Please ask for: Mrs D Johnson
Email: daun.johnson@arun.gov.uk
Telephone: 01903 737762
Our Ref: BR/242/20/PL
Your Ref:
Date: 14th October 2020

Application for Planning Permission

Development: Access ramp. This application affects the setting of a Listed Building, affects the character & appearance of the Bognor Regis Railway Station Conservation Area & is in CIL Zone 4 (Zero Rated) as other development.
Location: 51 Canada Grove Bognor Regis PO21 1DW

No.	Description	Date
Client:	Bognor Town Council	
Address:	51 Canada Grove, Bognor Regis, PO21 1DW	
Project:	Disabled Access Ramp	
Drawing title:	Block Plan	
Project No	SSE_194	
Date	09-10-20	
Drawn by	IA	
Drawing No	BP01	
Scale1:500@A3

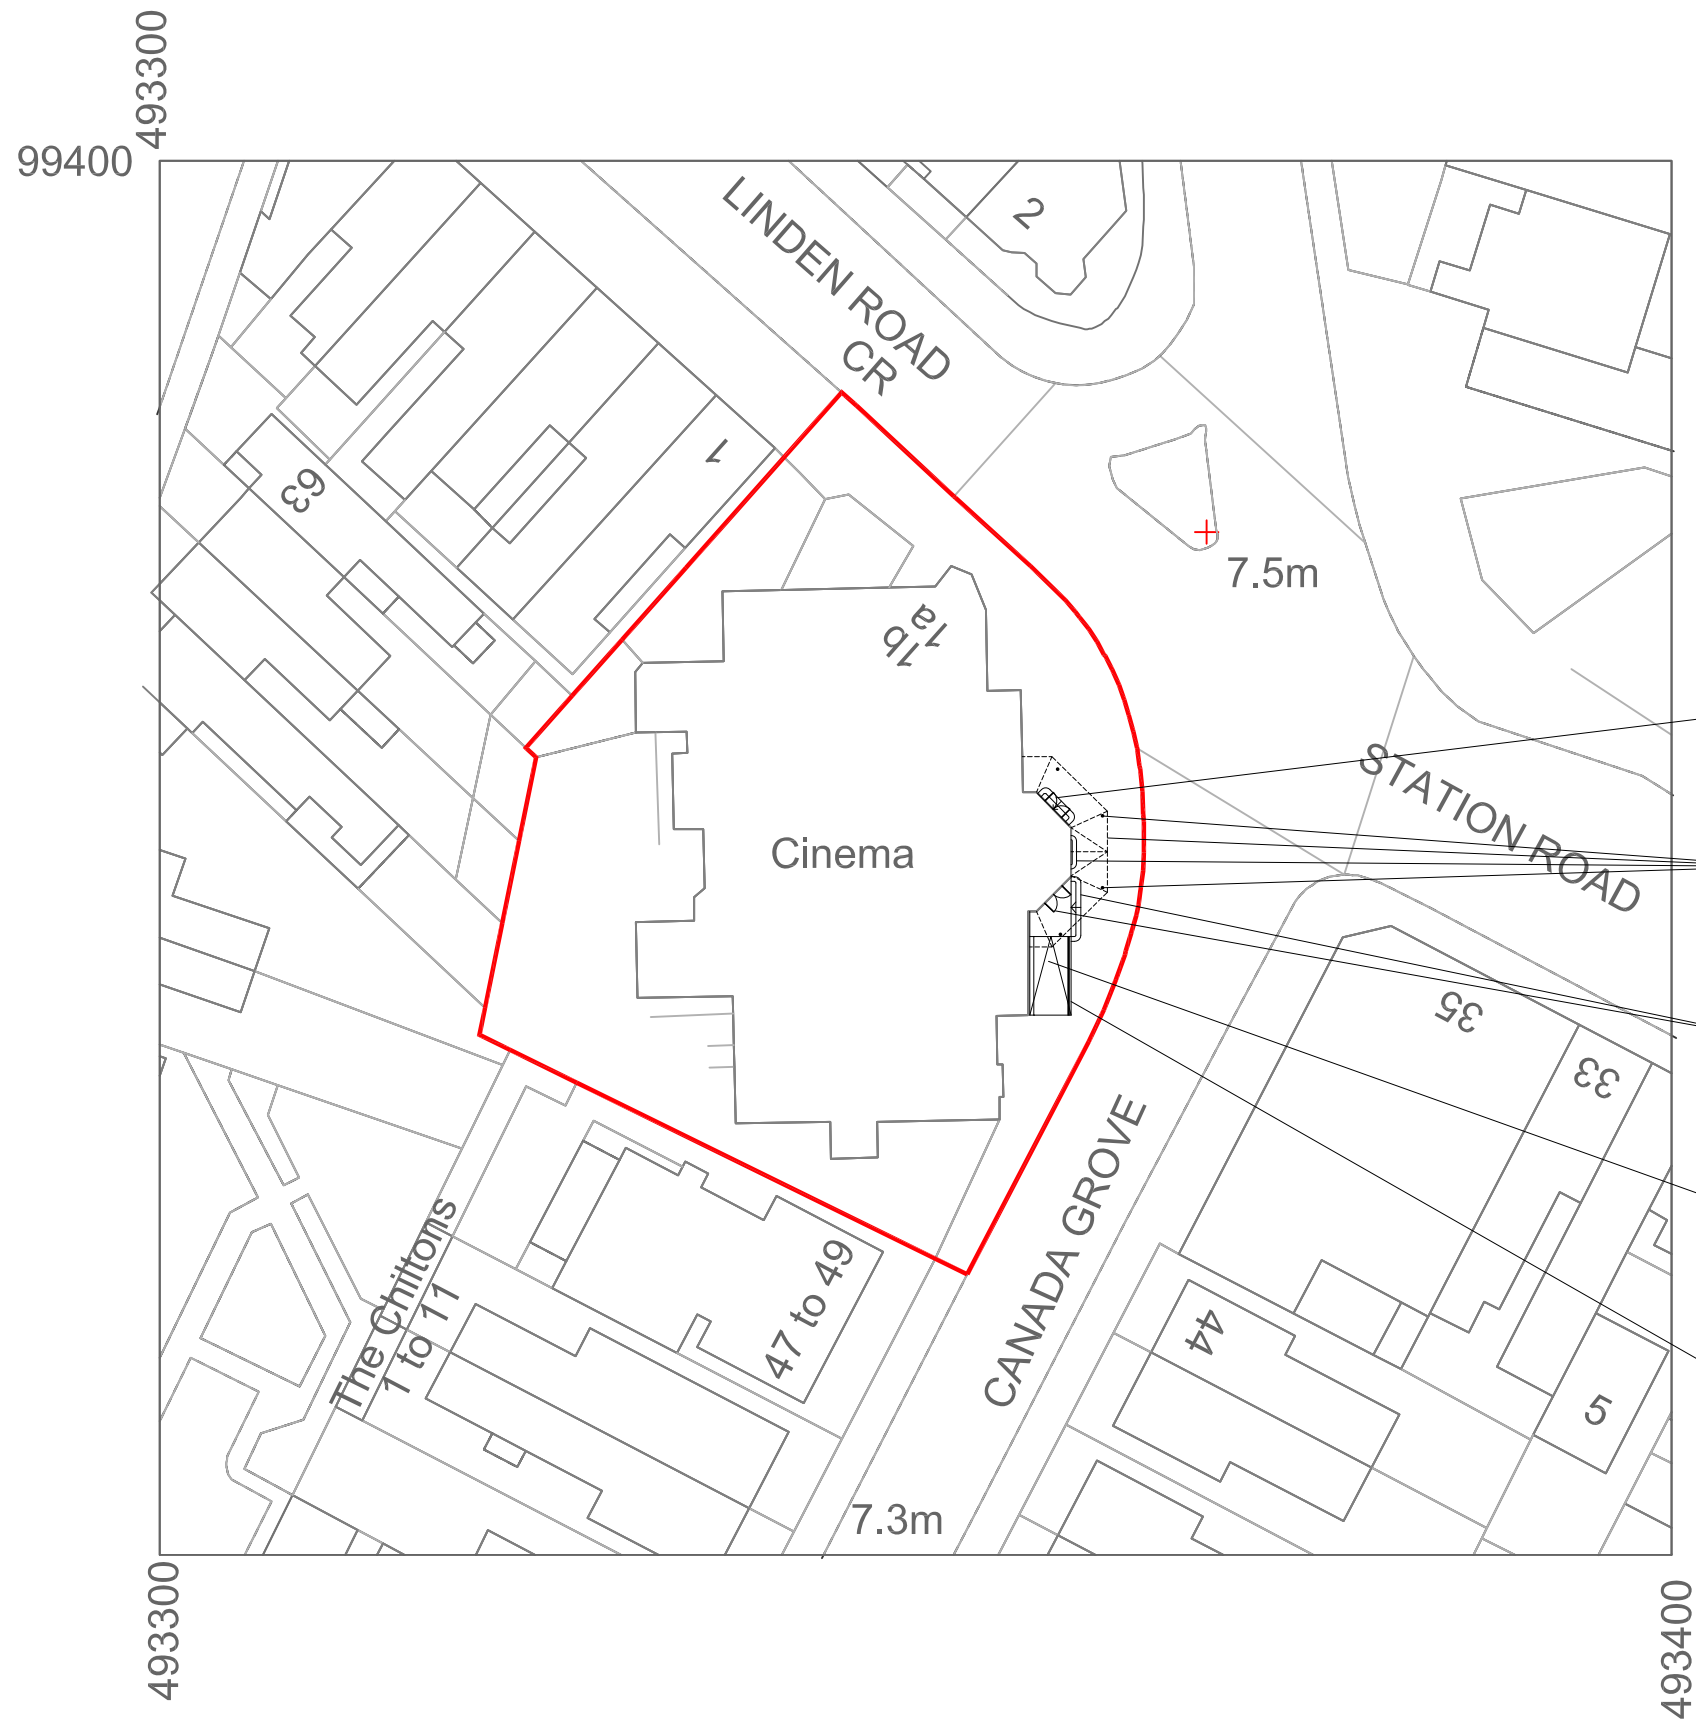
Block Plan

Please provide a North point.
CIL Additional Information Form
